N.C. DEPARTMENT OF ENVIRONMENT AND NATURAL RESOURCES
DIVISION OF ENVIRONMENTAL HEALTH

Comment Addendum

COUNTY: Harnett
NAME: Matthews Landig ID: _____
STREET: _____
CITY: _____ DATE: 9/3/25
STATE: _____ ZIP CODE: _____ TIME: _____

## Overall Pool Layout Plan

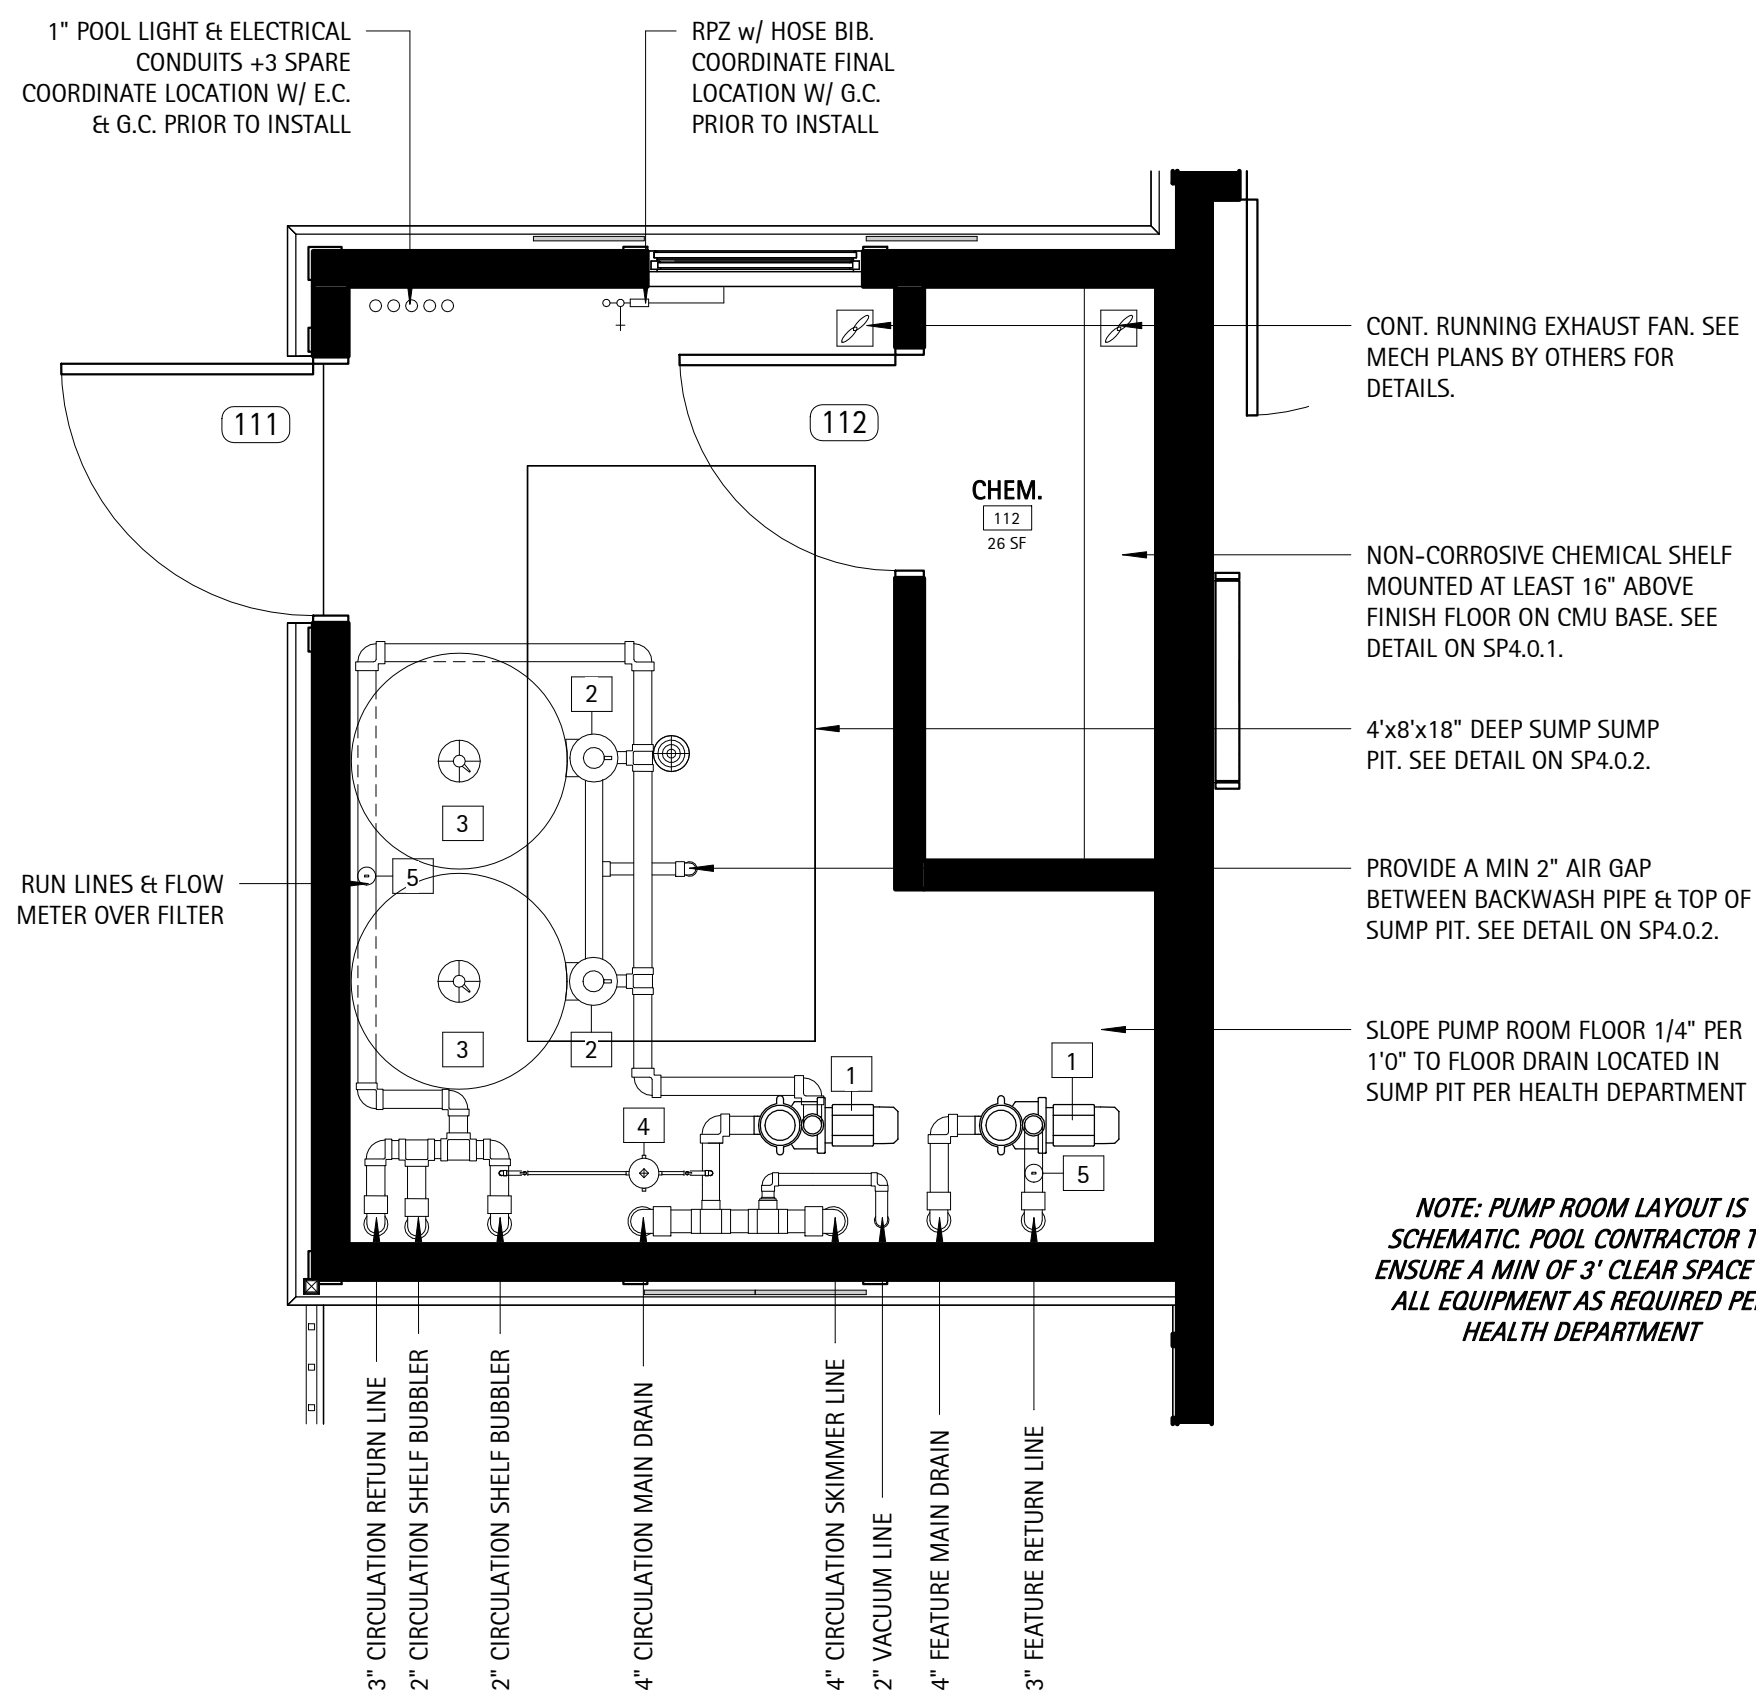
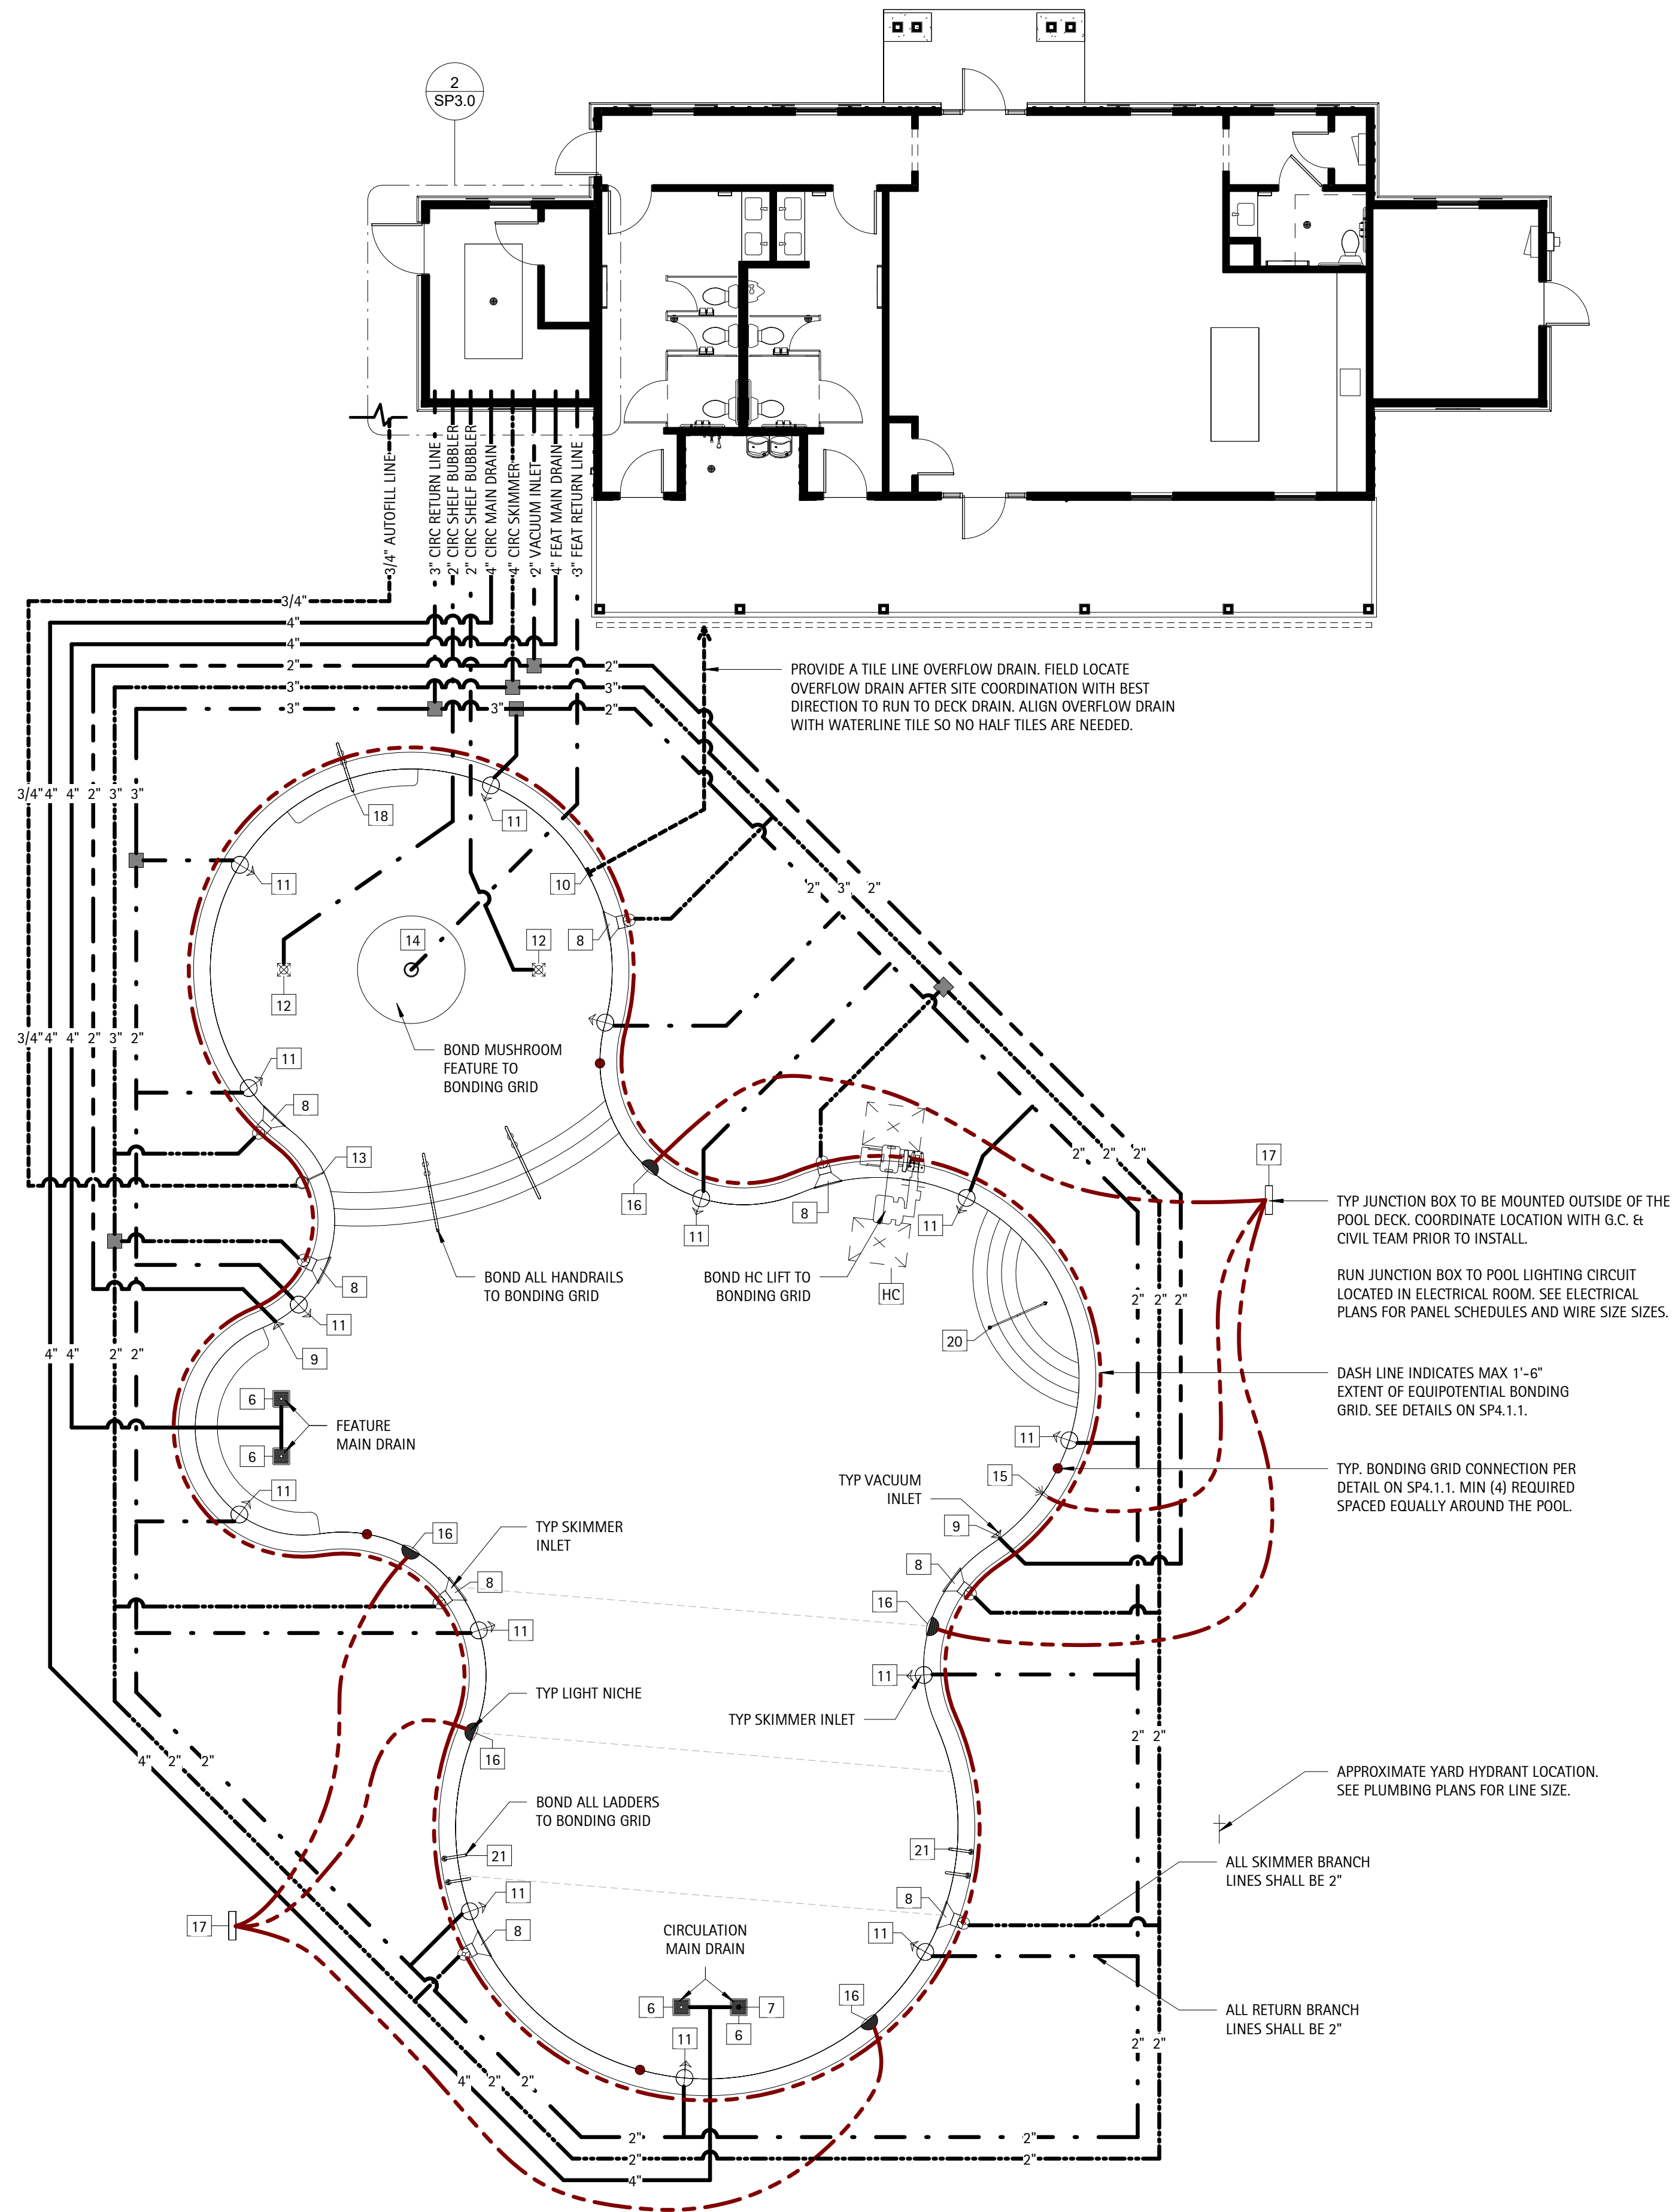
- 2nd Lang Plumb - Auto-fill connected to Return Stubout -
No Stubout provided for auto-fill
- Section of piping is 3", plans spec 2" (pipe
was marked during inspection)
- Excessive bends/connections present in some areas
- minimize unheeded bends (those beyond spec plans)
where possible
- Suspended & unsupported pipe present in multiple
locations - scribbles marked on site to be
placed prior to backfill in an attempt to add support
